***MODIFICATION REQUEST:
Westmead Millennium Institute at the
Westmead Health Campus
(MP10_0050 MOD 2)***

- Modification to the access arrangements, detailed design, construction work hours, ESD initiatives and travel demand requirements for the Westmead Millennium Institute.

Director-General's
Environmental Assessment Report
Section 75W of the
Environmental Planning and Assessment Act
1979

December 2013

NORTH ELEVATION

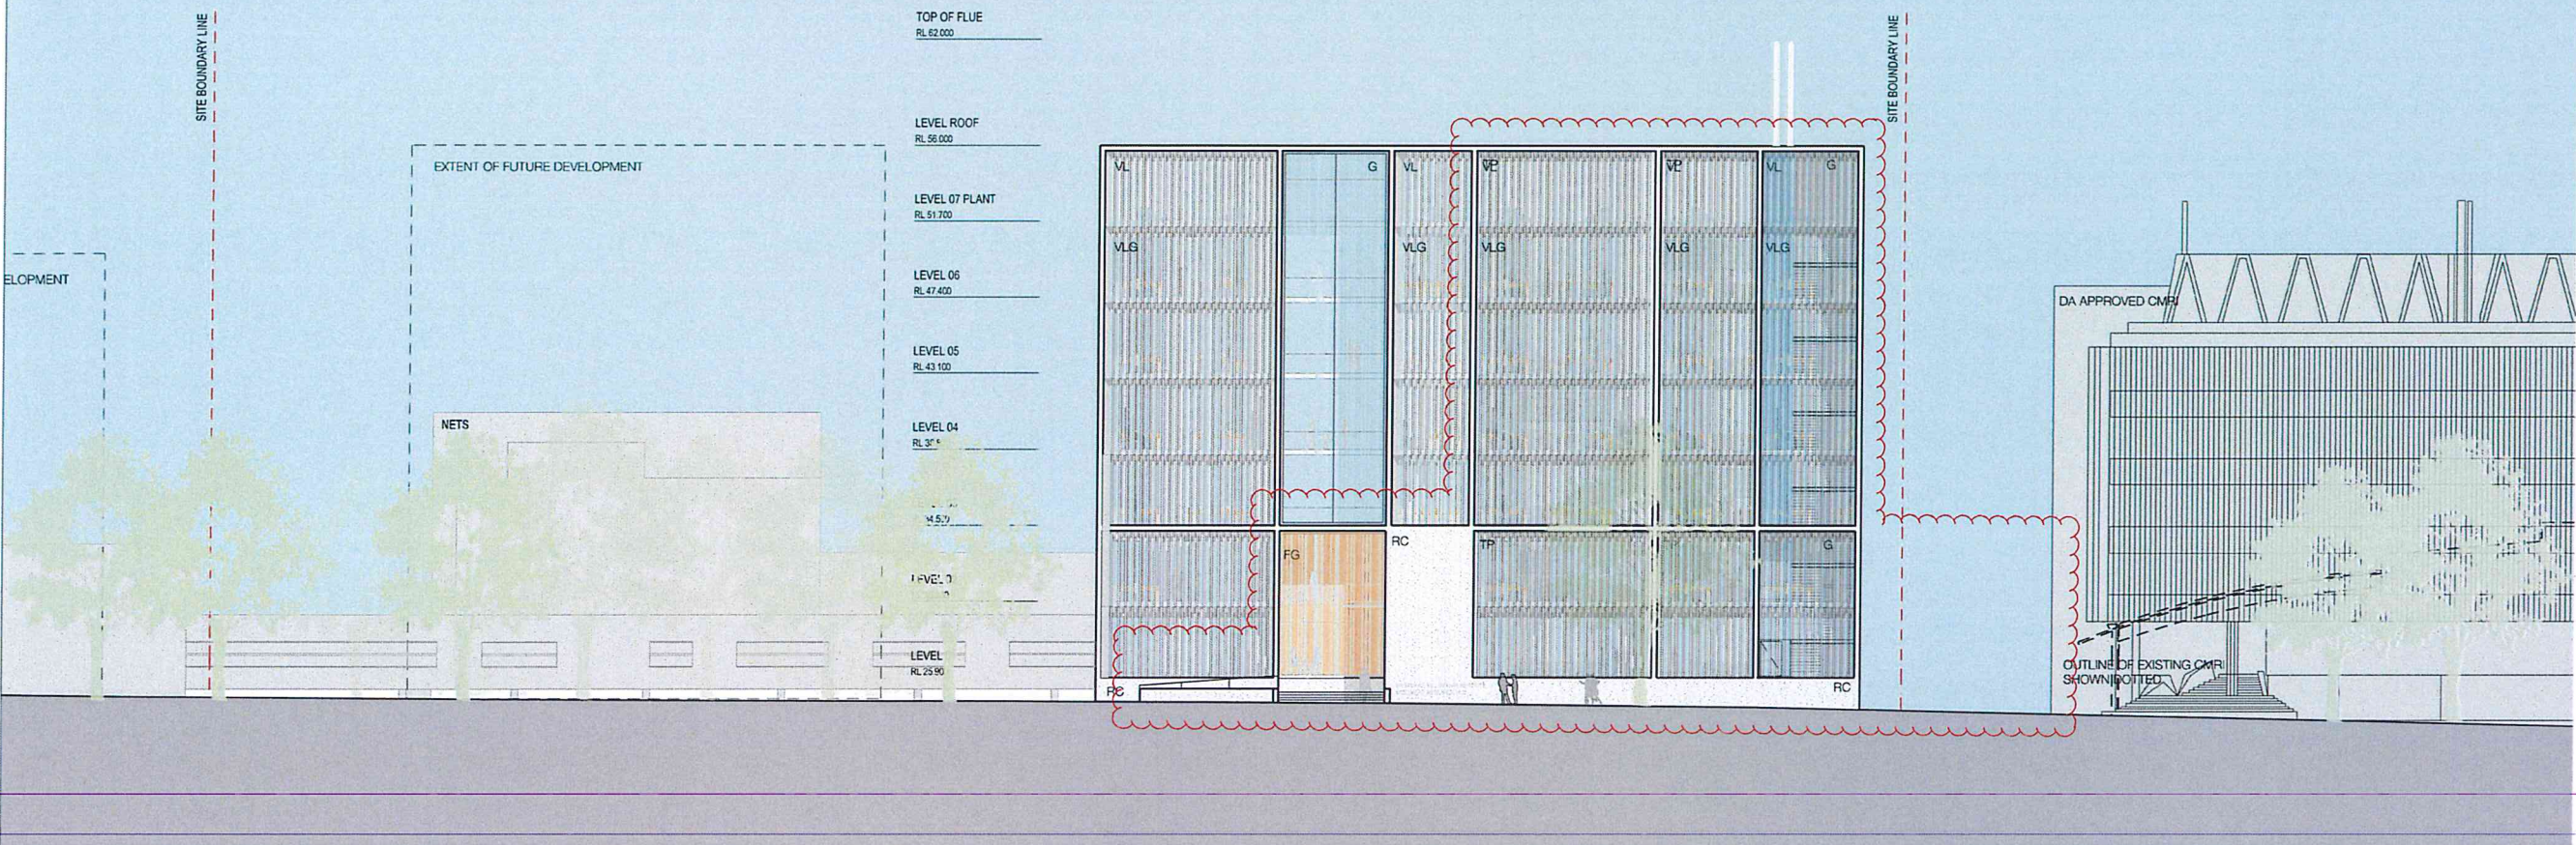
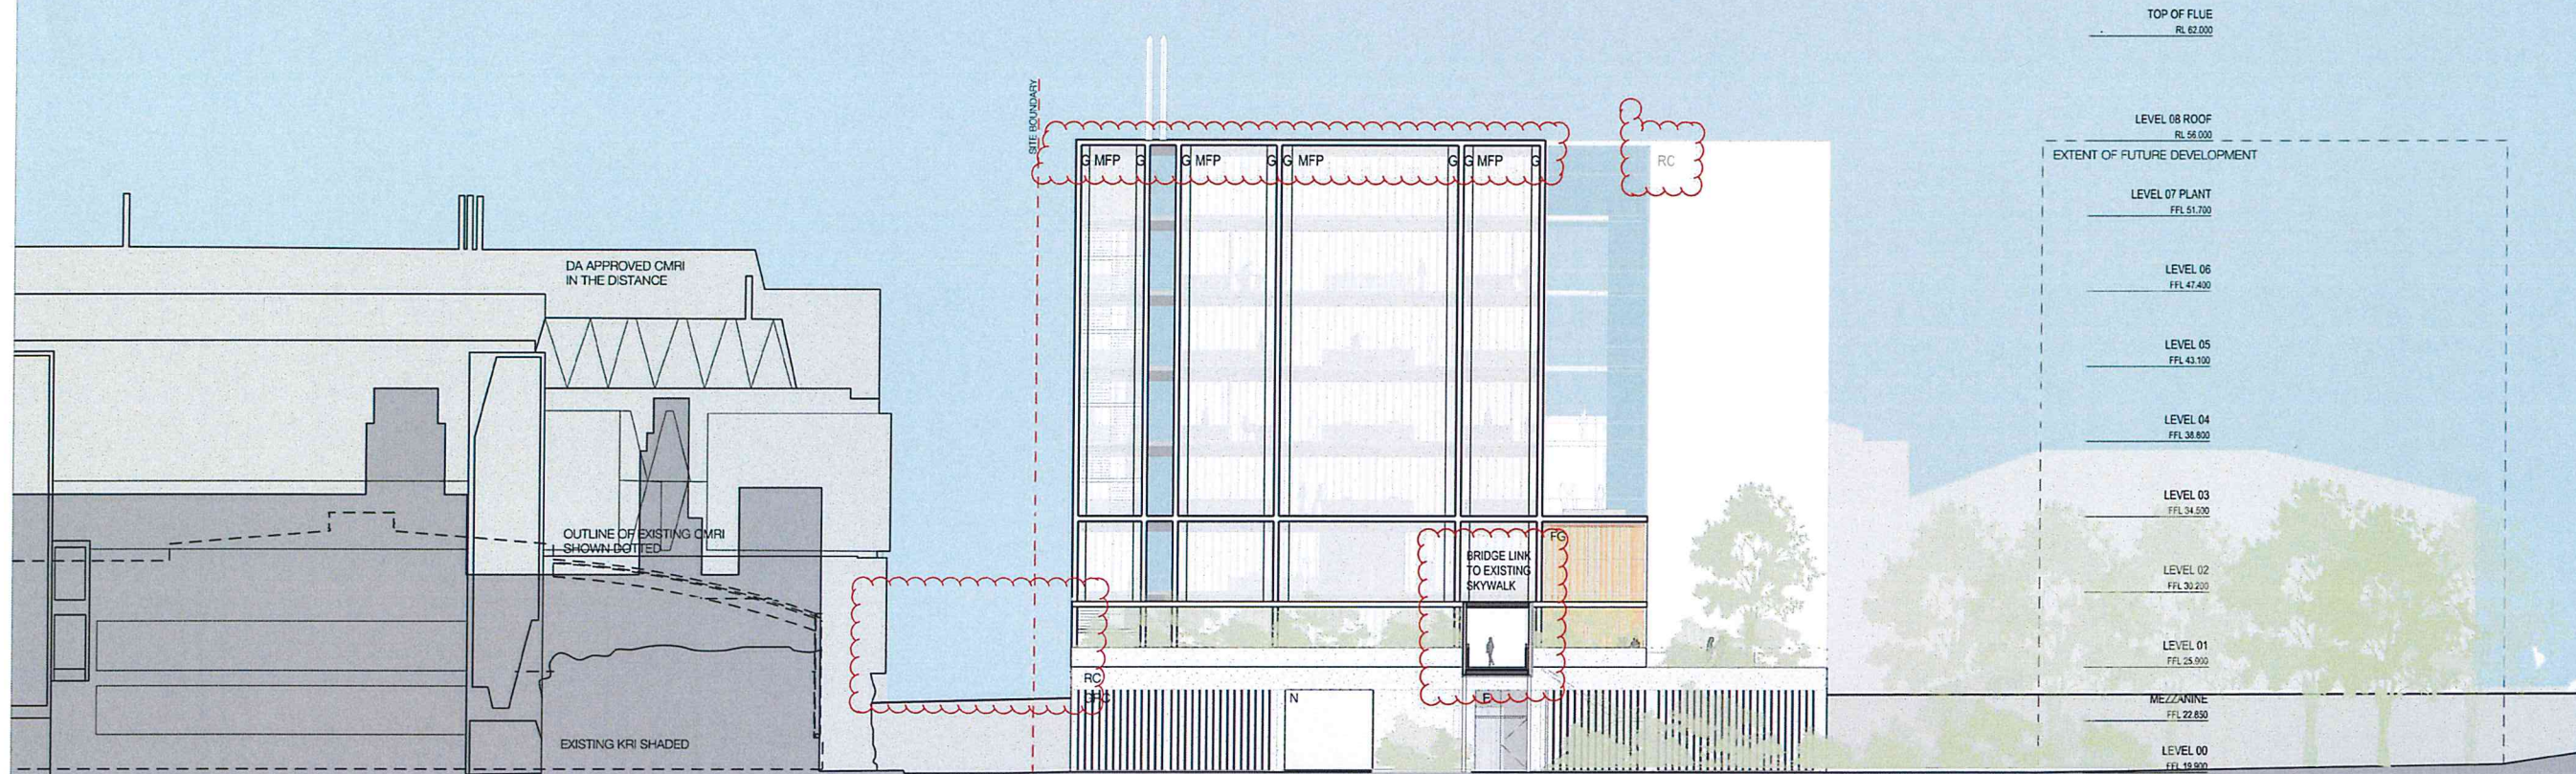
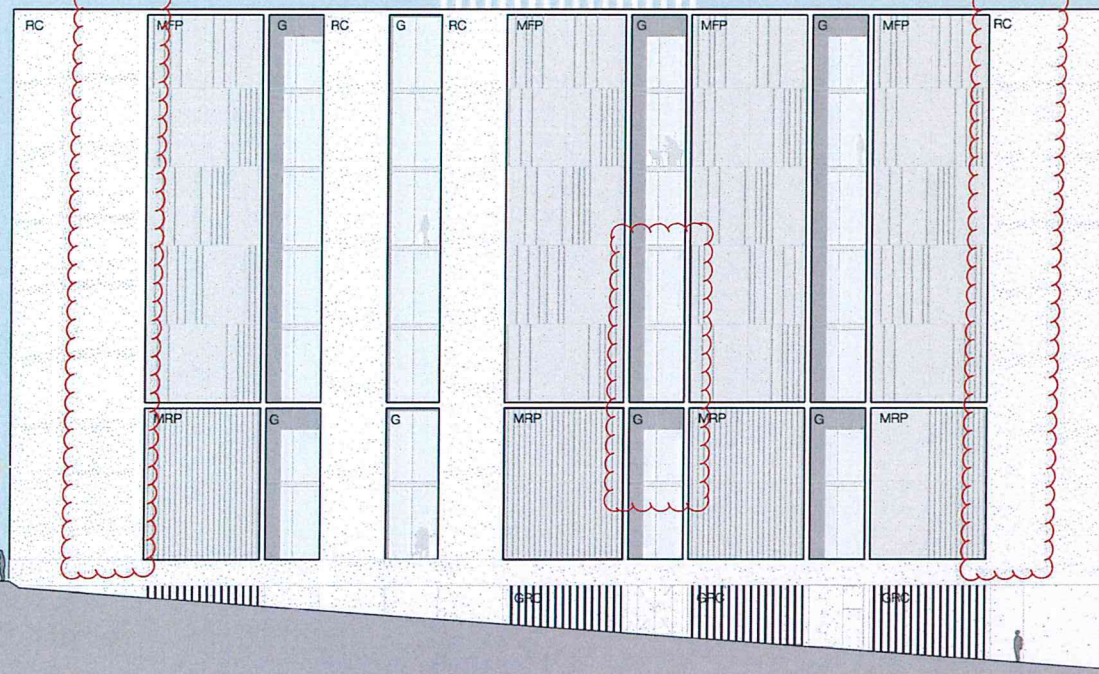
Elevation	Proposed Change
North	• The translucent façade panels will replace solid façade panels; • The extent of vertical louvres and glazing will be reduced; and • The vertical louvres and glazing in the setback area will be replaced with a concrete wall.
East	• A section of glazing at eastern and western end will be replaced with concrete.
West	• The glazed façade at the upper ground level adjoining the café will be moved to the west.
South	• Translucent façade panels will be replaced with glazed and solid façade panels with vertical louvres; • The glazing adjacent to the main entry will be replaced with a concrete wall; and • The extent of vertical louvers at northern end of the façade will be increased to screen the escape stair.

Since the project approval was granted, the opportunities for elevated pedestrian bridges to the neighbouring CMRI building to the northeast are no longer available due to internal changes in the layout and configuration of the future CMRI building. These connections have now been deleted from the eastern elevation of the modified plans submitted with this application. However, the proposed modification also seeks to construct a bridge link at the northern elevation on the upper ground level, extending over the car park to the existing skywalk at the rear of the site. Given its location at the rear of the building, the proposed bridge link will not be readily visible from Hawkesbury Road and will have no significant visual impact from the public domain.

The proposed changes to the façade are in response to the evolution of the detailed design of the building and the functional requirements of the internal spaces. The department considers the changes in material will not undermine the original modern design and the building will continue to complement the existing and future character of medical research and hospital buildings surrounding the site. The proposed extension to the window line along the western elevation at the upper ground level will provide a more useable café protected from the elements.

The department supports the integration of facilities across the campus and considers the proposed bridge link acceptable.

The department considers the proposed changes to the design to be acceptable.
